City of Albuquerque
Planning Department
Inter-Office Memorandum

SUBJECT: Project # 1009204

On May 10, 2012, the Environmental Planning Commission (EPC) approved Project #1009359/12EPC 40015/40018, a site development plan for building permit and a zone change from RA-2 to SU-1 for PRD for all or a portion of Lot 33, Alvarado Gardens, Unit 1, located on Rio Grande Boulevard NW between Contreras Place & Matthew Avenue, containing approximately 1.2 acres.

A1 SITE DEVELOPMENT PLAN FOR BUILDING PERMIT
SCALE: 1" = 20'

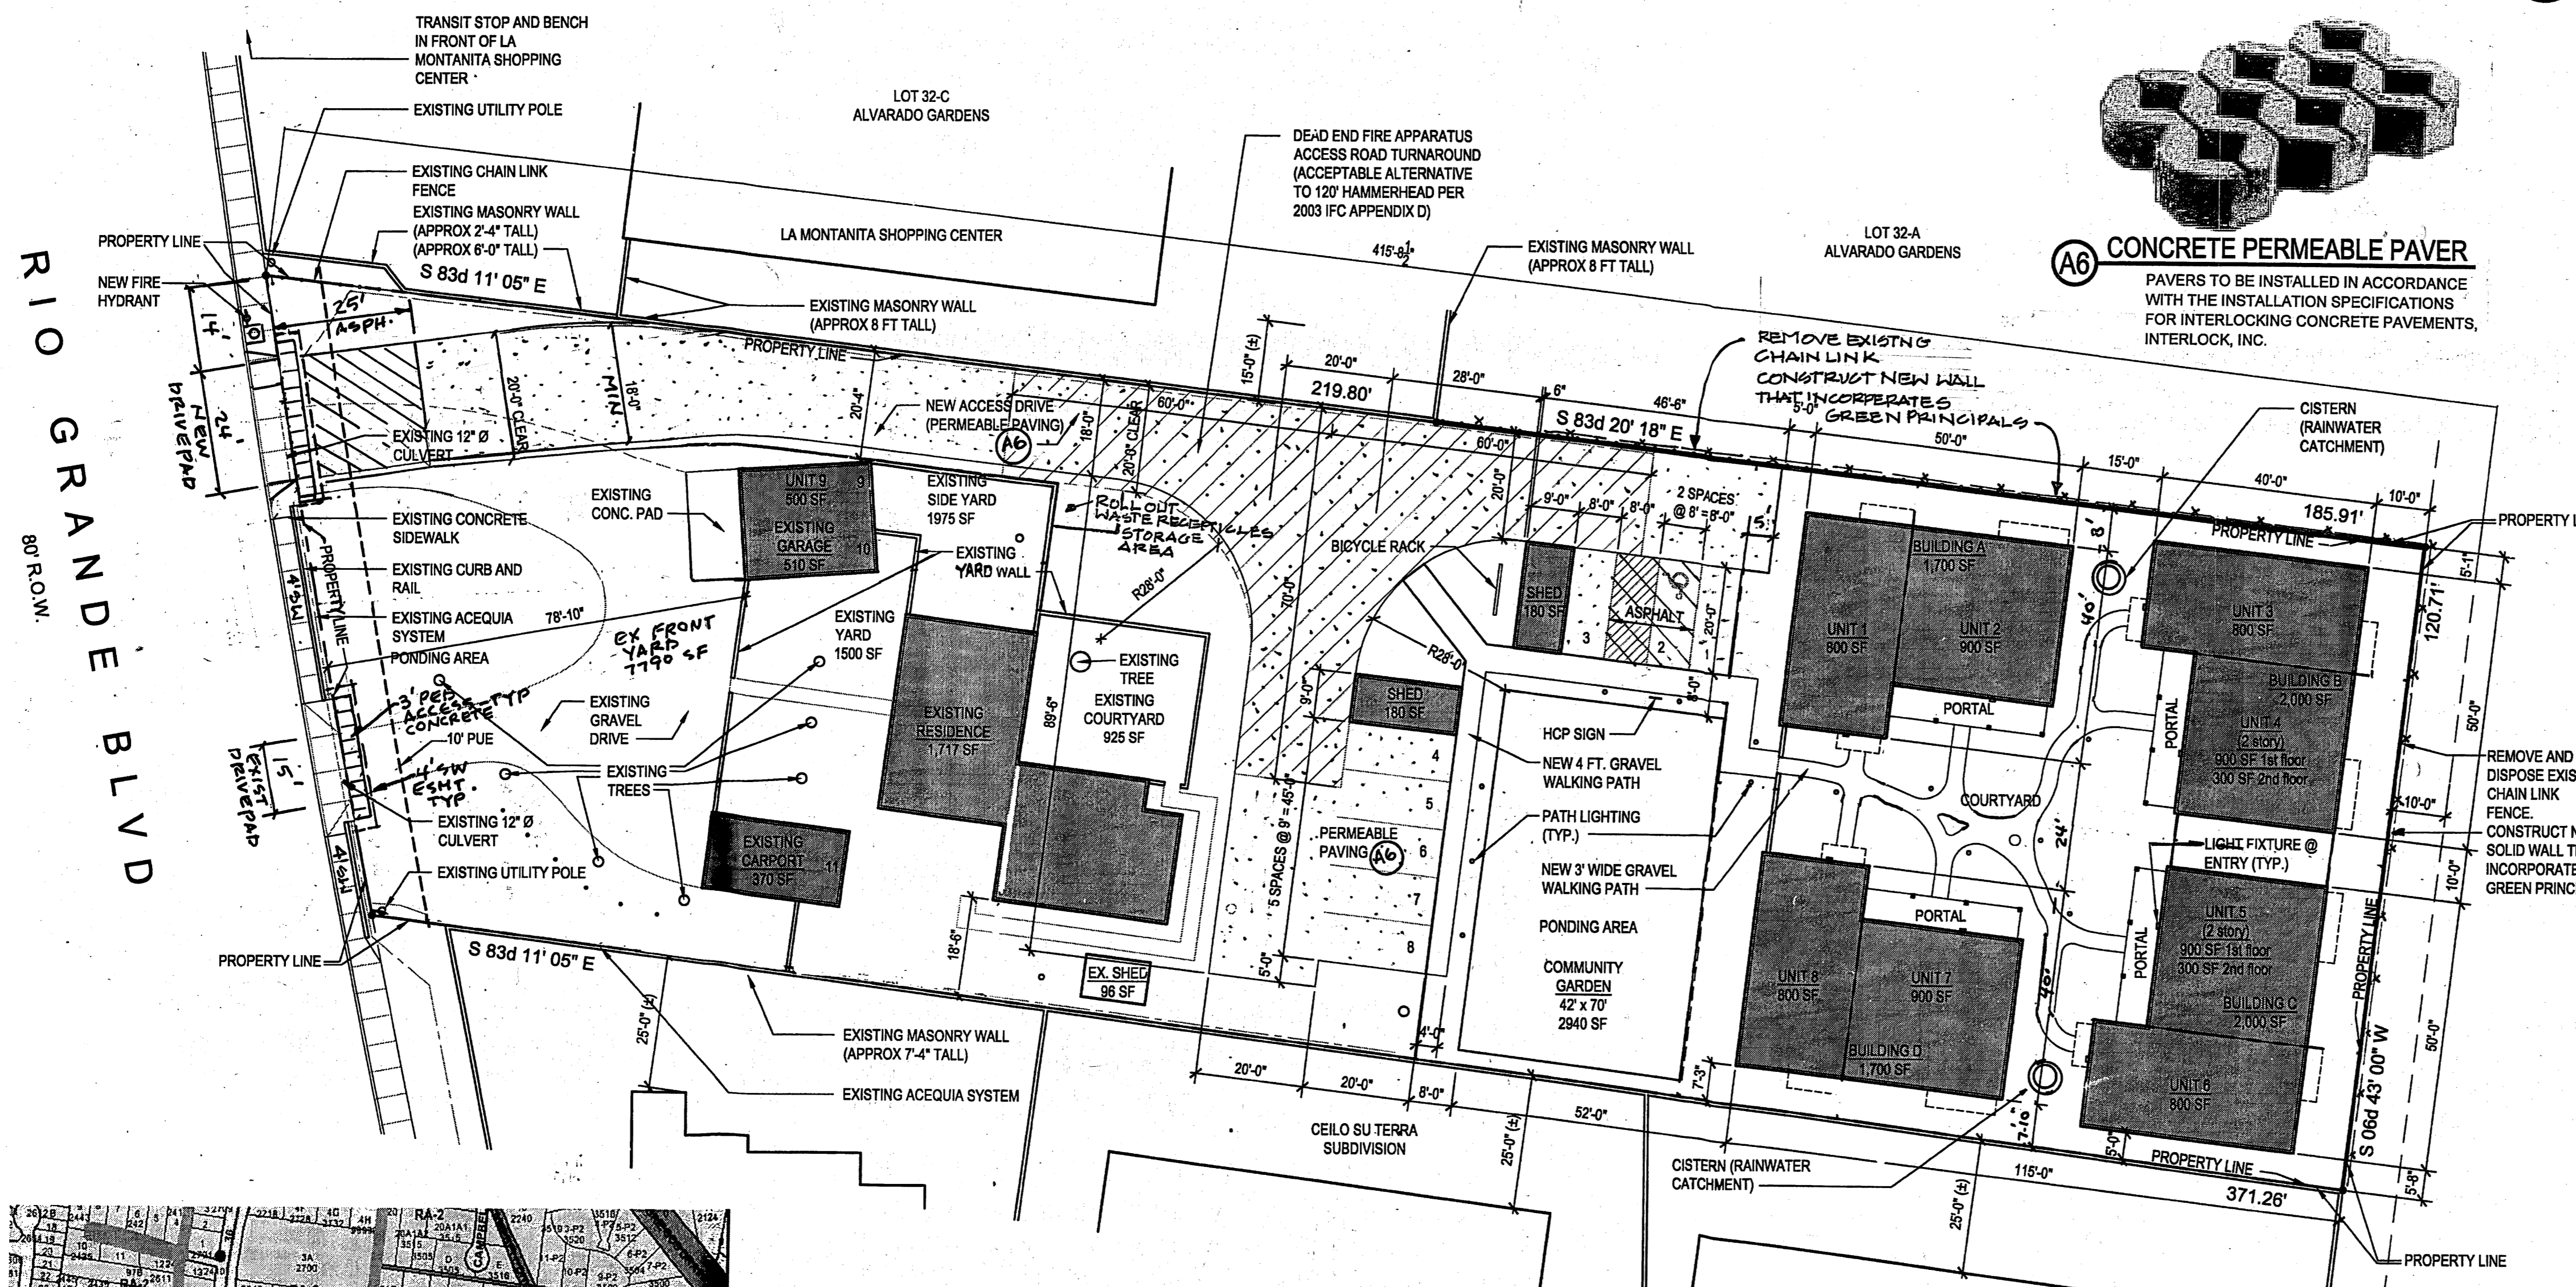
4. After meeting with and getting approval from the Solid Waste Department, a note shall be placed on the site development plan for building permit indicating how solid waste will be handled at the subject site.
-Solid waste management has signed the plan; however, the applicant has not included a note that shows how solid waste will be handled at the site.

5. The site plan for building permit shall change the words "base course and crushed rock" to "permeable paving" and indicate the difference between the two by using different shading or hatching along with a corresponding legend.
-Applicant has completed this condition with the exception of identifying permeable paving on the legend.

B1 LANDSCAPE PLAN
SCALE: 1" = 20'

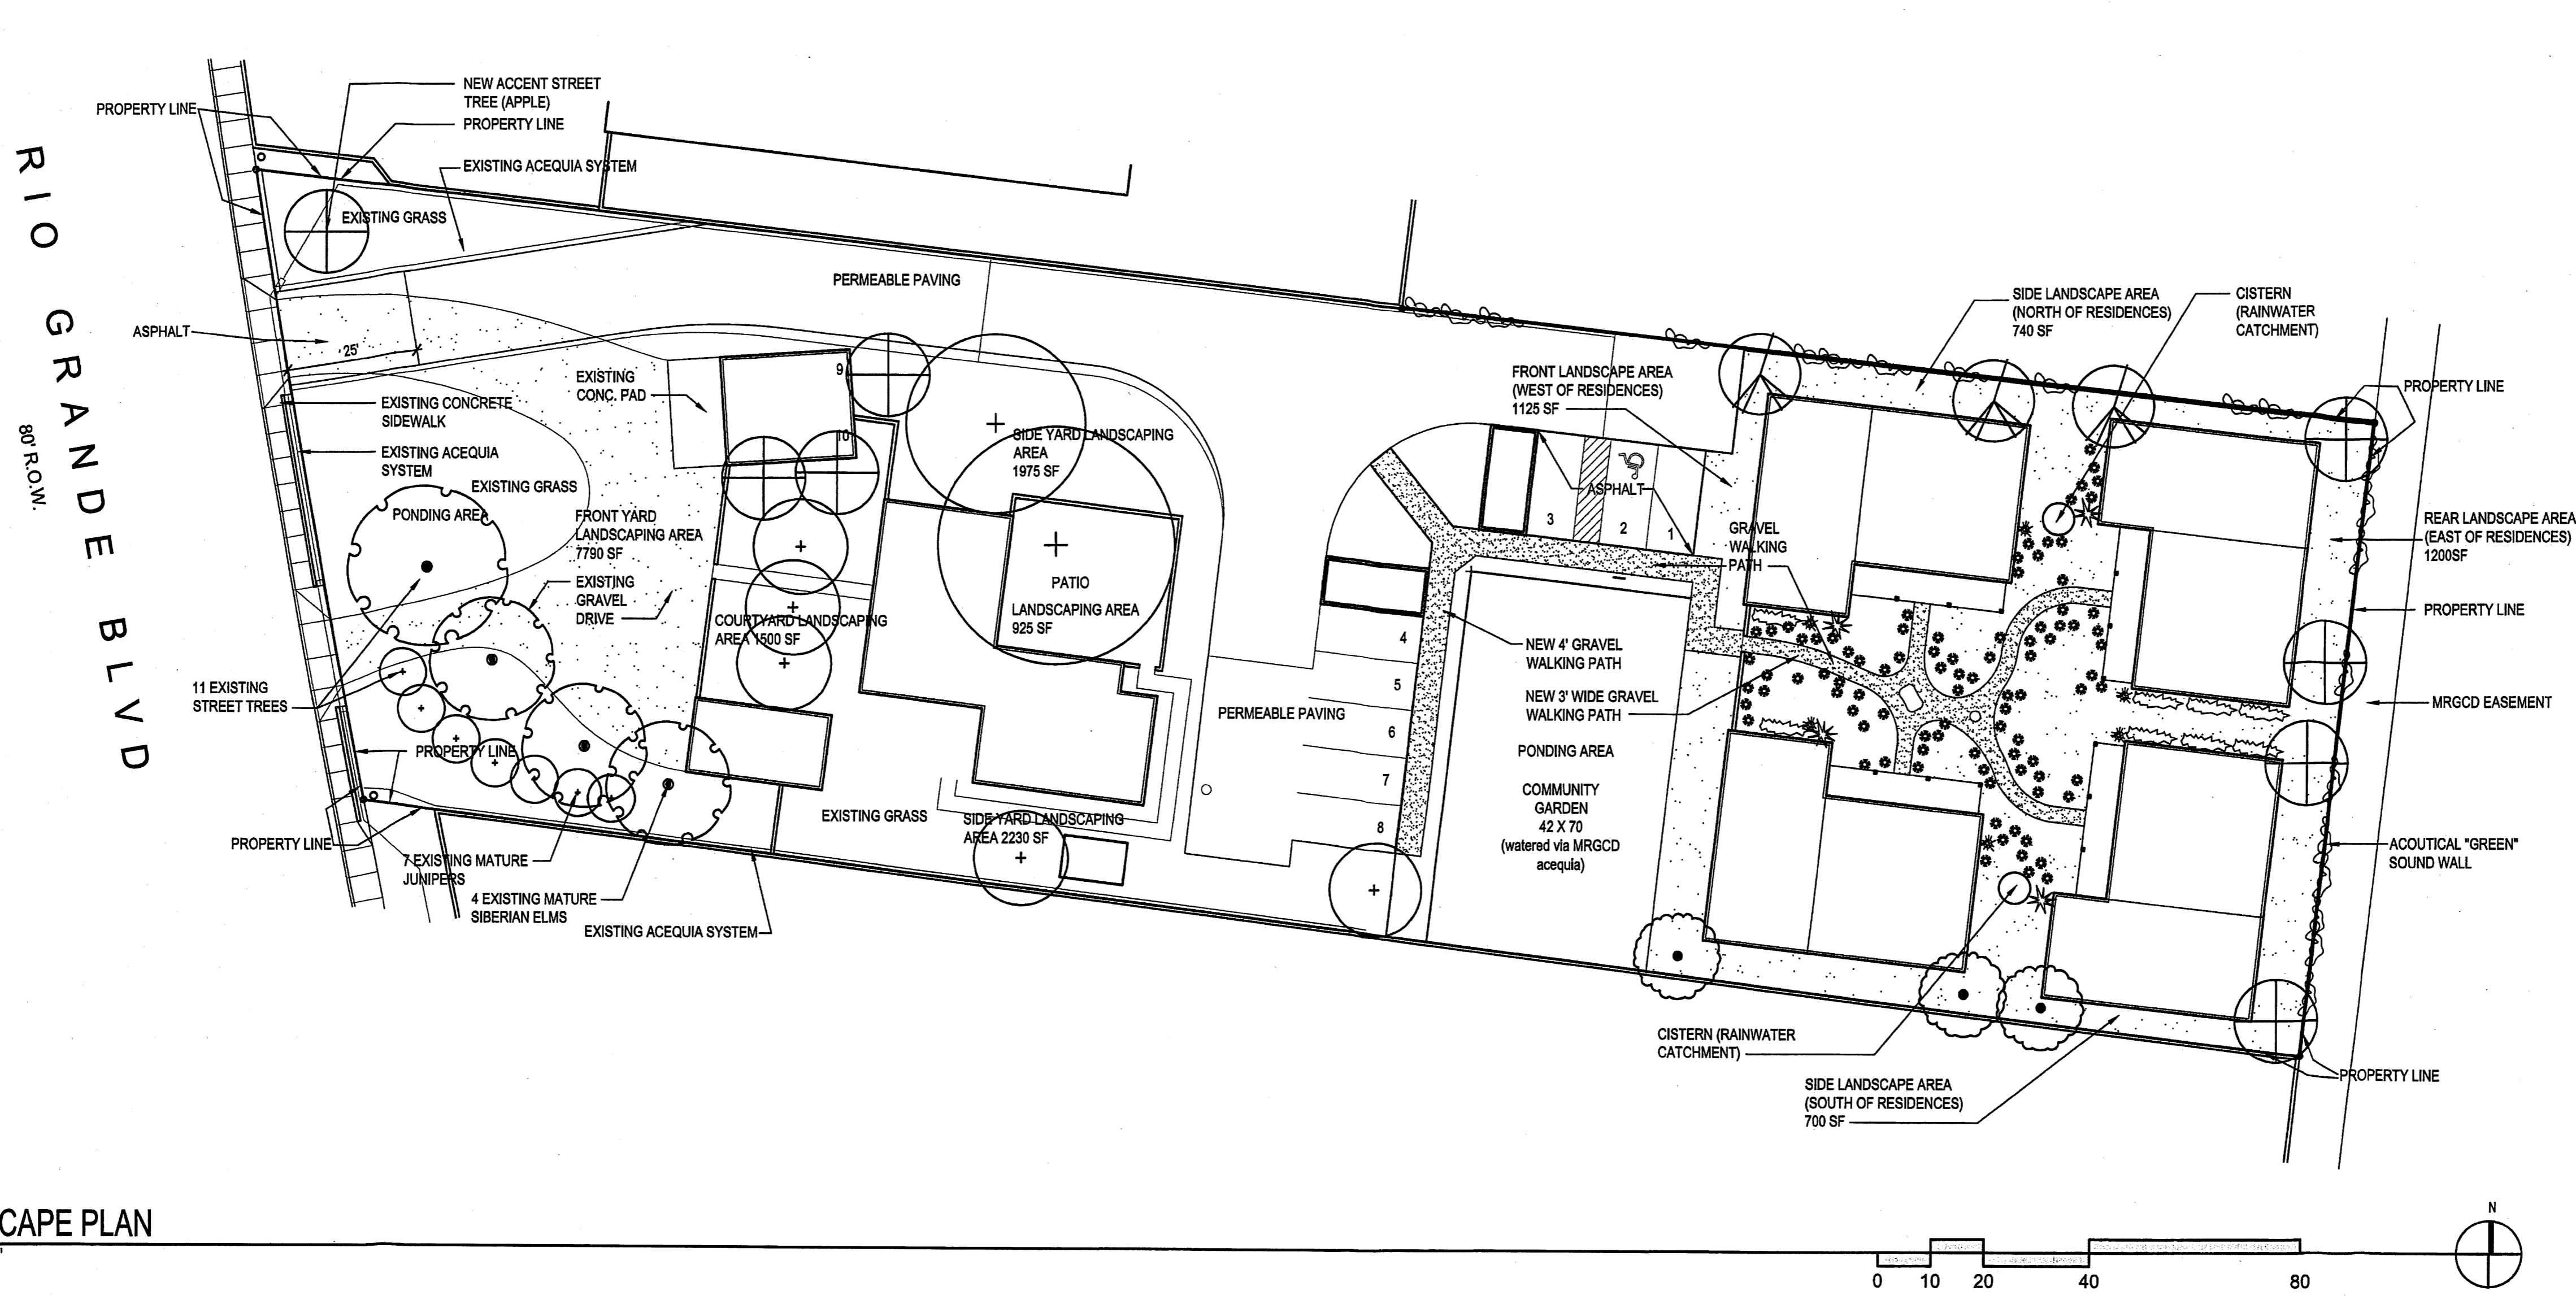
7. The landscape plan shall show the following: mature size of landscaping, square footage of the landscaping in the courtyard area, and required number of street trees.
-The mature size of all landscaping needs to be shown. Mature size of Buffalo Grass and Trumpet Vine has not been shown on the landscape plan. In addition, the minimum acceptable sizes of plants at the time of planting are as follows: (1) Trees. Two inches in caliper measured six inches above grade, or 10-12 feet in height. (2) Shrubs and low-growing evergreens: one gallon (Section 14-16-3-10)(F). The Apple, Pear, and Cherry trees are shown at an installed size of 5' minimum. Buffalo Grass also does not show the installed size, quantity, or water use and Trumpet Vine does not show the quantity or installed size.

-Street trees are defined in the Street Tree Ordinance (Section 6-6-2-1) as "A tree growing within 20 feet of the edge of a street that directly or indirectly affects public passage or safety and comprises a street tree pattern adjacent to a street." The applicant has shown "Street Trees provided (5) within 25' of property line and "Street Trees
